Our ref: T13003

20 March 2013

**Subject: Building Code of Australia Capability  
61 Mobbs Lane, Epping - Stage 3 – Basement carpark**

DRAWING TITLE: LOWER GROUND 2	PROJECT NO:	DATE:	DRAWING No:	REV:
	697	MAY 2012		
	DRAWN BY:	SCALE:		
	GO	As indicated	A0001	1
	CAD FILE:

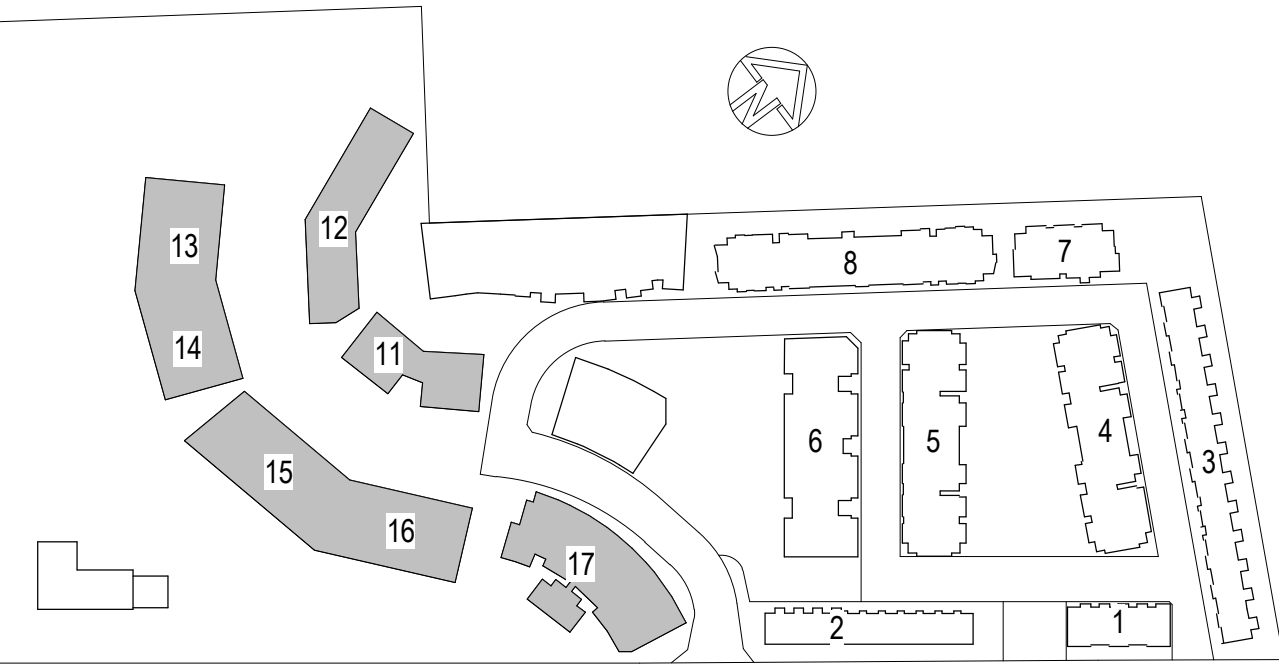
- (i) The distance of travel from the bike storage area adjacent to the driveway on the carpark level exceeds the maximum stipulated in BCA Part D1.
- (ii) Provision must be made for the installation of a hydrant booster valve assembly and pump room to the requirements of AS 2419.1-2005.
- (iii) Provision must be made for the installation of a sprinkler booster valve assembly and pump room to the requirements of AS 2118.1-1999.
- (iv) Additional fire hose reels will be provided adjacent to the exit stairways to achieve the required coverage.

Whilst these aspects of the design do not currently satisfy the Deemed-to-Satisfy requirements of the BCA they are capable of being addressed at the Construction Certificate stage by either minor design changes or by the development of an alternative solution to the Performance Requirements.
